City of Albuquerque Stormwater Construction Site Inspection Report

ESC File No.	C10E001A	Project Name:	Sonata Green			
NPDES Id. No.	NMR1003AC	Location:	Tree Line Ave. and Universe Blvd.			
5/25/2021	Owner		Contractor			
Operator	Sonata Green, LLC.		Wexford Construction			
Contact name & title	John Murtagh		JL Murtagh			
e-mail	jmurtagh@wcinm.com		JL@wcinm.com			
Contact Phone #	702-376-5287		505-259-3397			
COA Inspector	Thomas Evans		Start/End Time:	9:25 AM/10:05 AM		
Construction Phase:	Grading					
Type of Inspection:	Regular	Storm Event	Past Storm Event >0.25"	311/Complaint	Follow Up	
Weather at time of inspection?	clear		Temperature:	~ 67		
Estimated date of last storm 0.25" or greater	5/3/2021

ESC-1

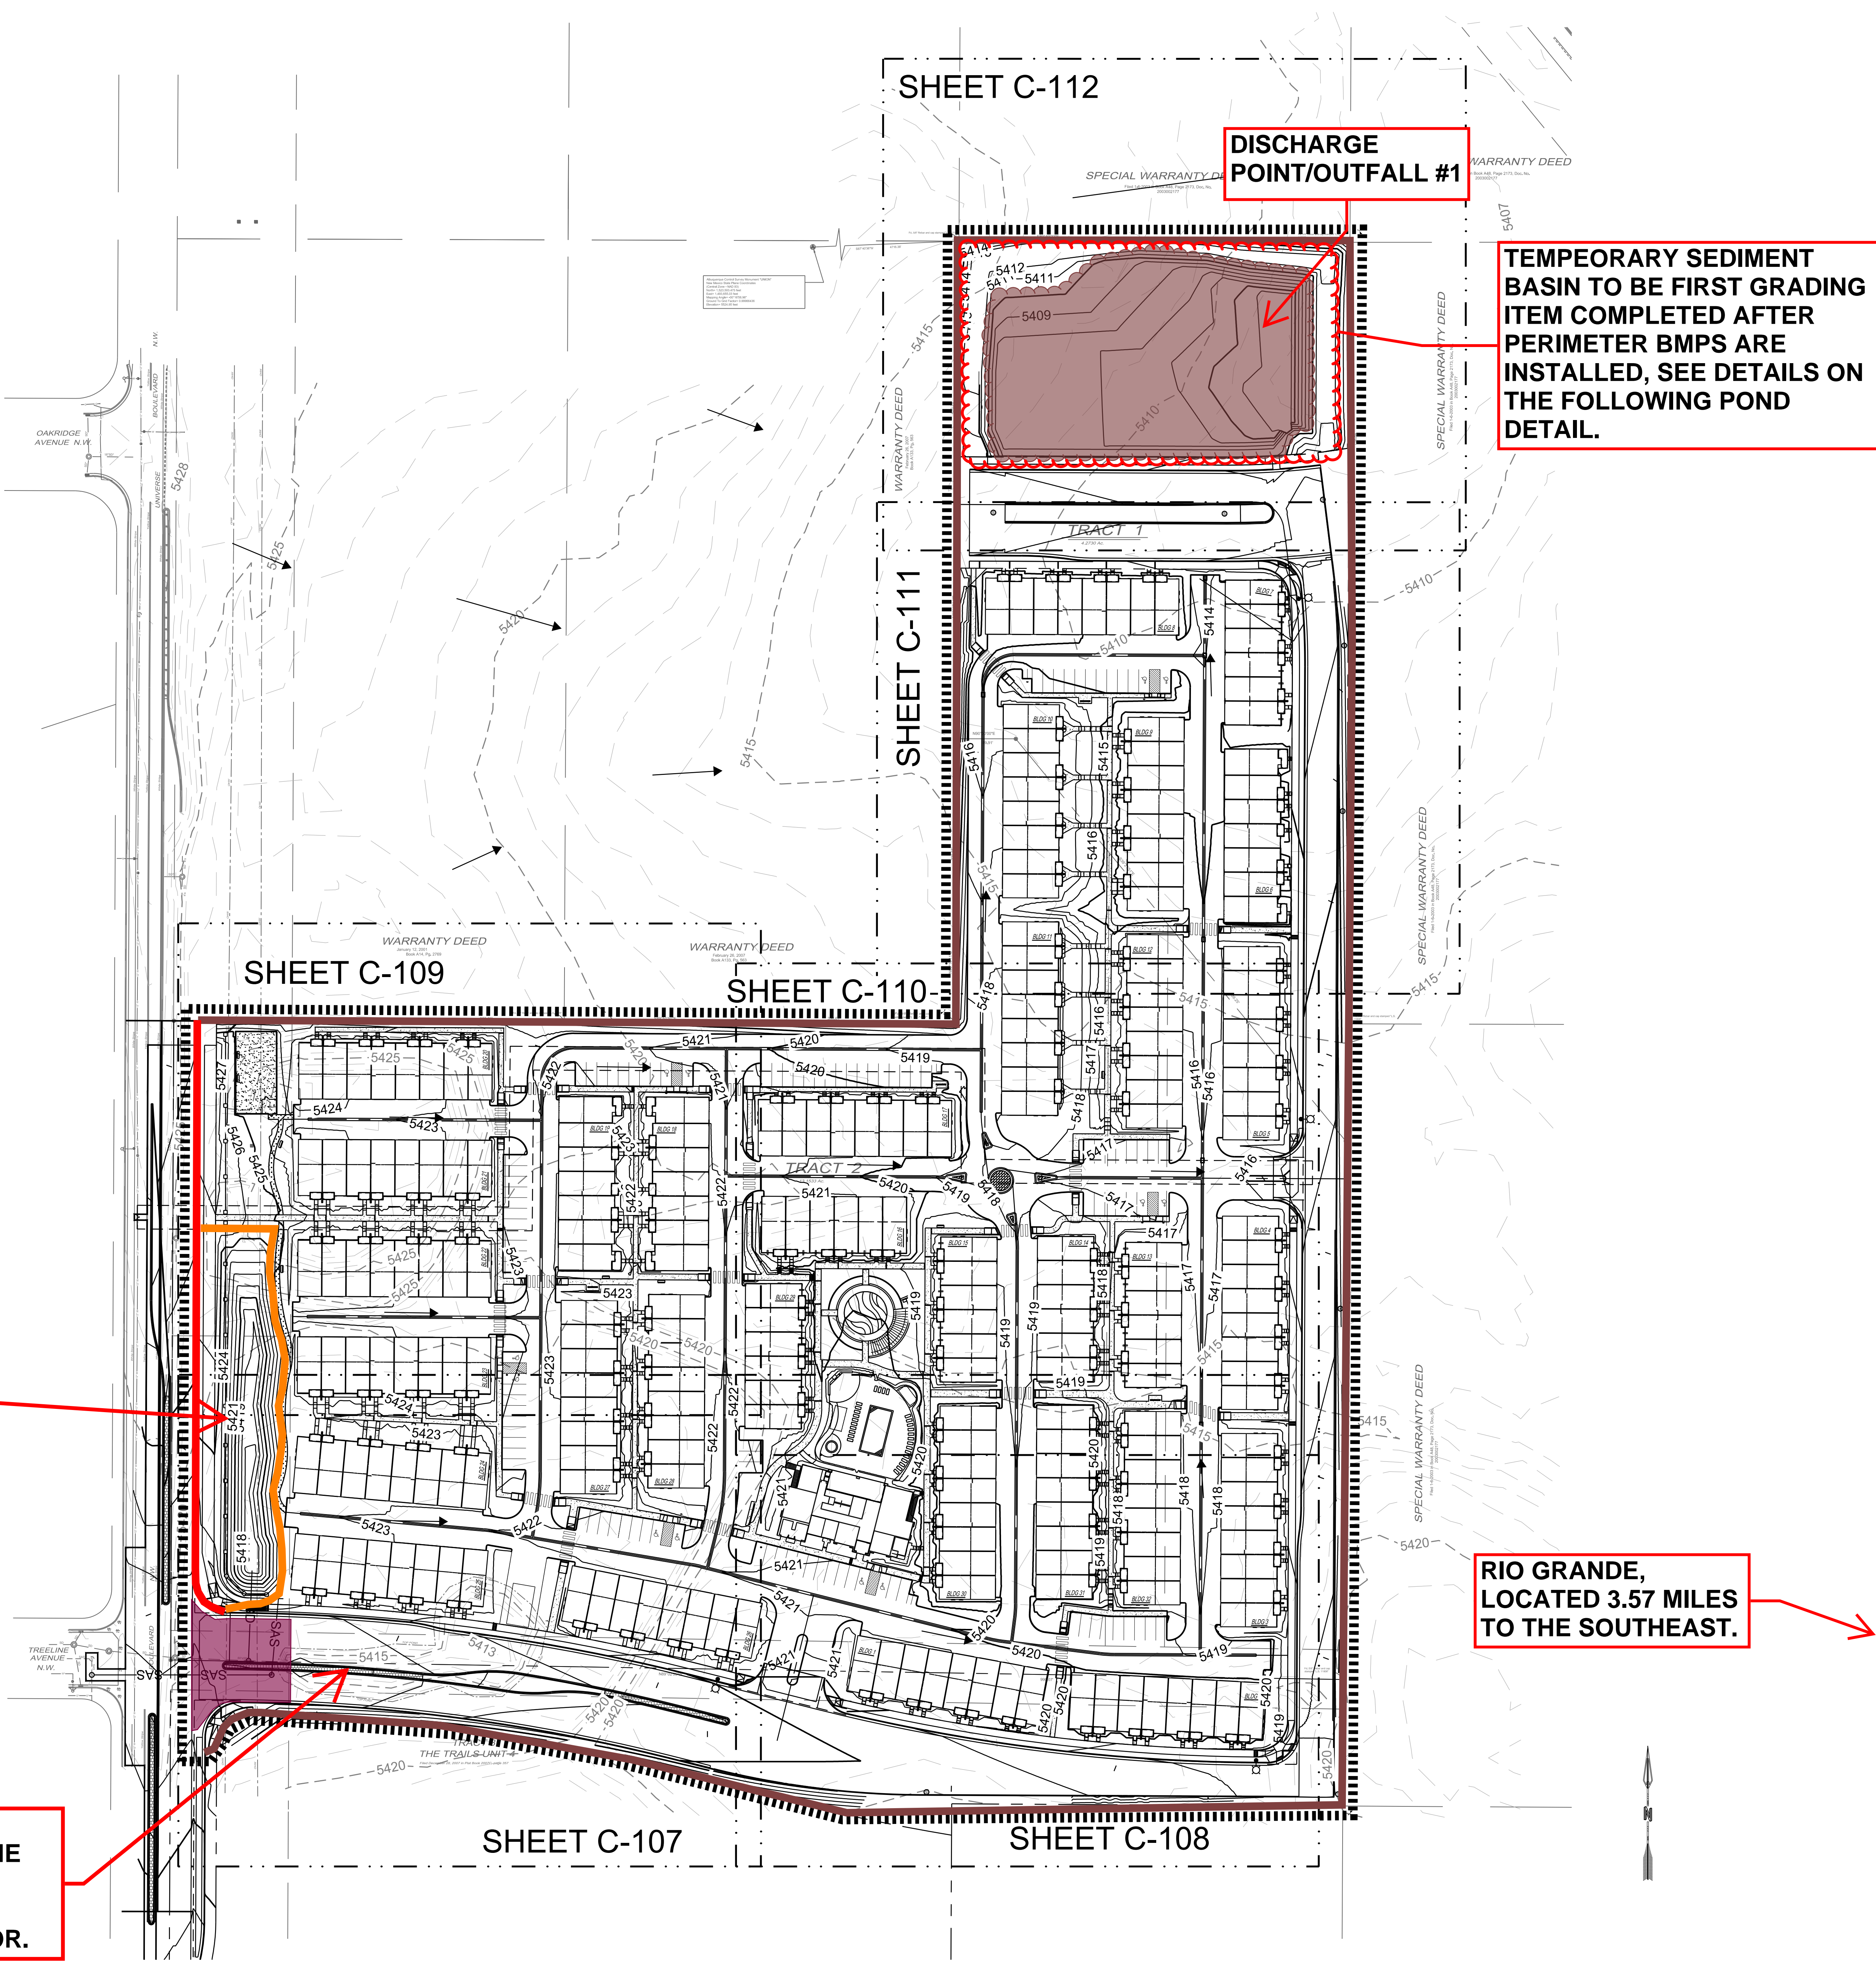
Item Number	Deficiency/ Corrective Action					
1	Silt fence down at NW corner of site. Re-install silt fences to prevent sediment from exiting the site.					
2	Maintain track-out pad.
